Please ask for: Ms Iqraa Malik
Email: iqraa.malik@terraquest.co.uk
Telephone: 01212341390
Our Ref: BE/145/20/HH
Your Ref:
Date: 9th December 2020

Application for Planning Permission for Works or Extension to a Dwelling

Development: A Trapezium kitchen extension room, 5m width x 3.5m (exterior dimensions), in addition to a false garage frontage, incorporating another trapezium outbuilding area for utility use, (non habitable), with a 900mm side alley leading to rear.

Location: 5 Bucksham Avenue Bersted PO21 5DT

AMENDED(2) BLOCK PLAN

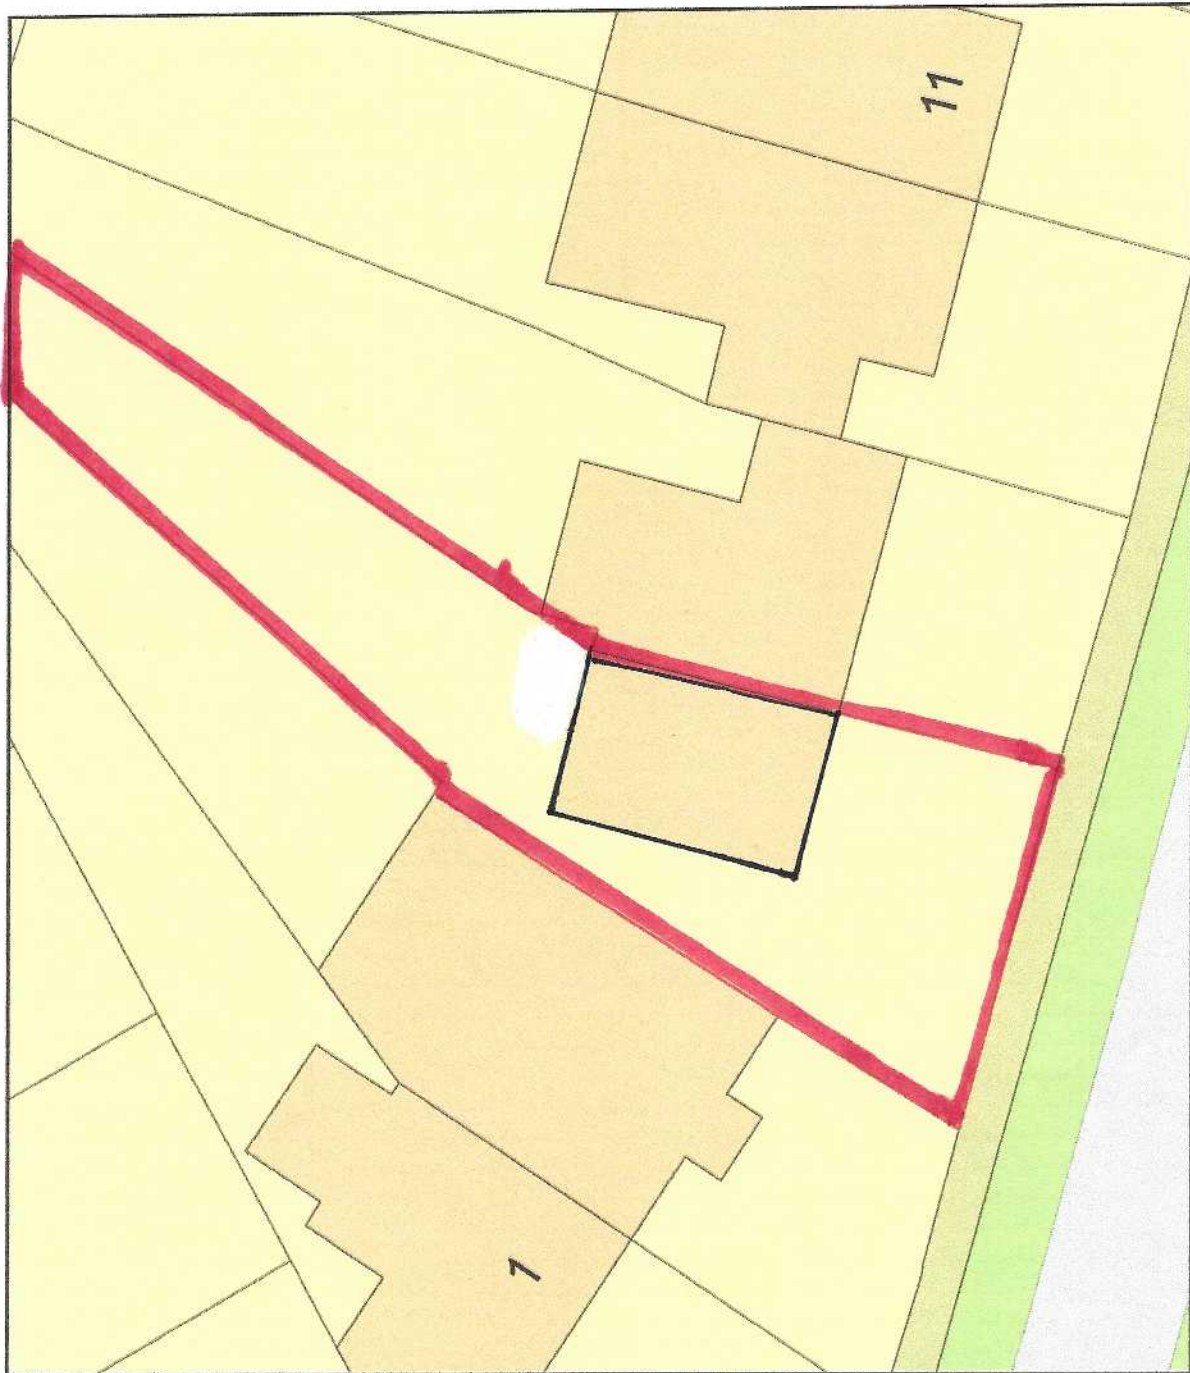
You are required to have dimensions from the proposed extension(s) to all site boundaries. Please amend.

5 Bucksham Avenue PO215DT - Location Plan

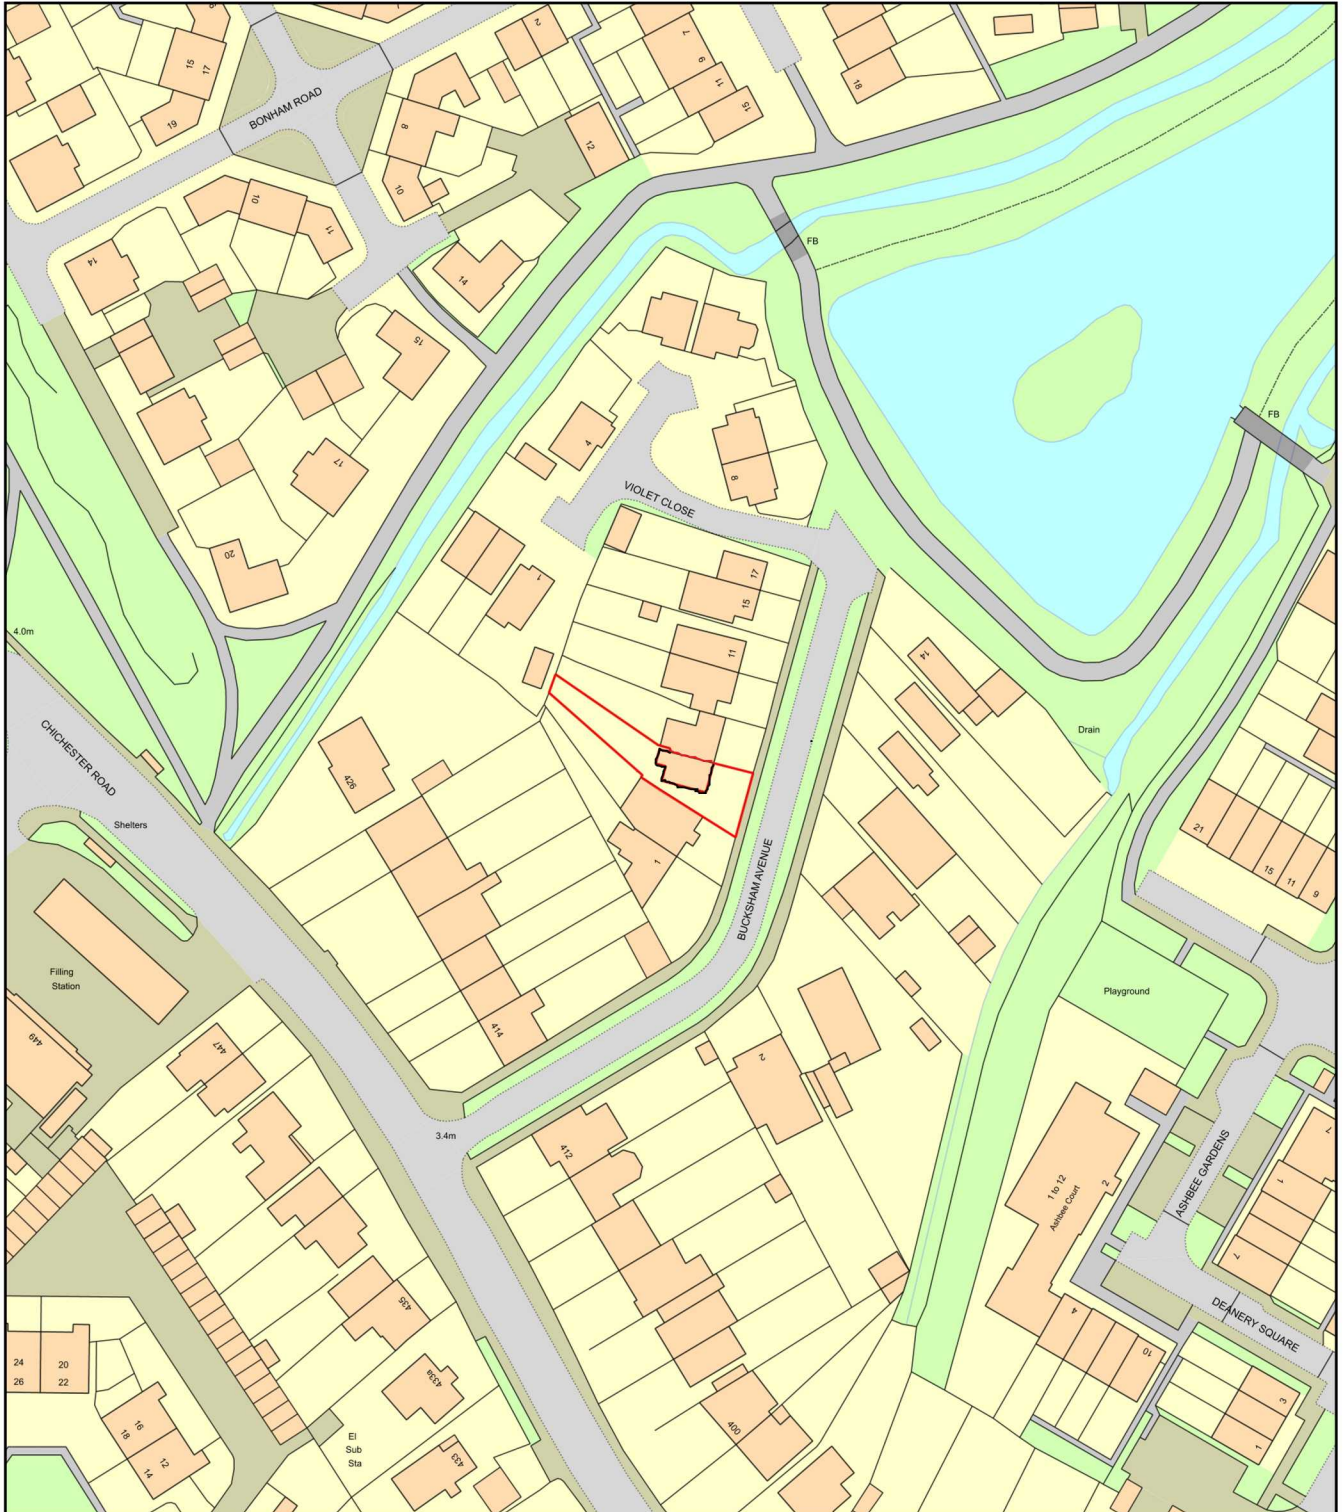
You are required to have a solid red outline around the entire proposed application site. Please amend. Further details of what must be included on the plan can be found in the Validation Requirements List.
